**Alternative Use Boston Projects  
Boston Alternative Energy Facility Order**

**Planning Inspectorate Reference: EN010095**

**Written Representations by  
the Environment Agency  
Unique Reference Number: 20028344**

**19 October 2021**

Plate A13.2-1 Long section of proposed wharf (yellow), tying in with final height of Environment Agency adaptive defences at 7.2 mAOD

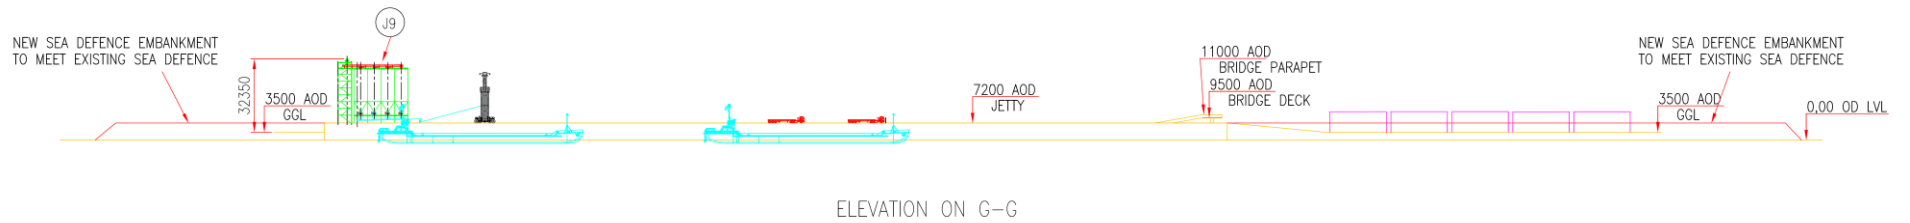
- 3.4 Notwithstanding paragraphs 13.1.127 to 13.1.133 of the FRA (APP-106), we do not consider that the impacts of flooding on any critical infrastructure within the site has been adequately considered. We require further clarification about what aspects of the development are considered critical, and what mitigation measures are in place to protect them. We recommend that any features considered to be critical infrastructure should be raised above the predicted flood level to ensure it is protected in the event of a flood.

- 3.5 We therefore maintain that the development does not pass the Exception Test as set out in Paragraph 5.7.16 of the Overarching National Policy Statement for Energy (EN-1), or the requirements of 5.8.18 of the Draft Overarching National Policy Statement for Energy in that it has not reduced flood risk overall.

**Figure 1.1. Ship Wash Wave Height Development over time as a Vessel Passes a Point (Gourlay, 2011)**

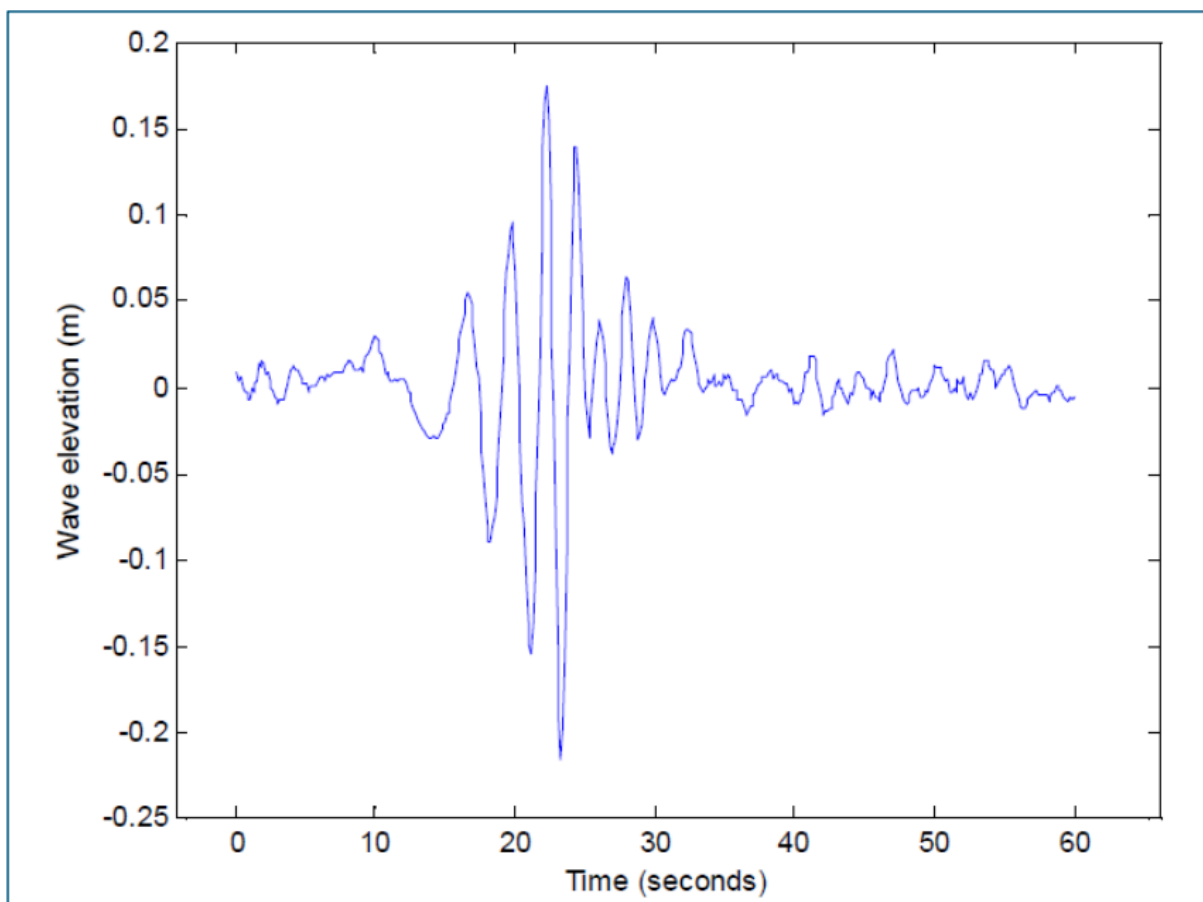
- 3.6 We note the applicant's assessment in their letter 'Boston Alternative Energy Facility: Geomorphology' to the Environment Agency (1<sup>st</sup> October 2021) that the increase in ship movements will result in an increase in ship wash in the Witham Haven. The applicant has assessed that the time ship wash affects intertidal mudflats will increase from 0.15% to 0.37% of the overall wave impact. Whilst we accept that this overall increase is small relative to the impact of natural wind-waves, we remain concerned that the combination of changes to the system dynamics through the creation of the wharf, the introduction of dredging and the increase in ship movements may result in increased erosion to the flood defences immediately opposite the site and to saltmarsh and mudflat habitats in the Haven (see paragraph 4.4 below).

- 3.7 We therefore request that the applicant provides further evidence of how the impacts of these changes have been assessed specifically in relation to erosion of both mudflats and saltmarsh in the area and any consequent impacts on the stability of existing flood defences.
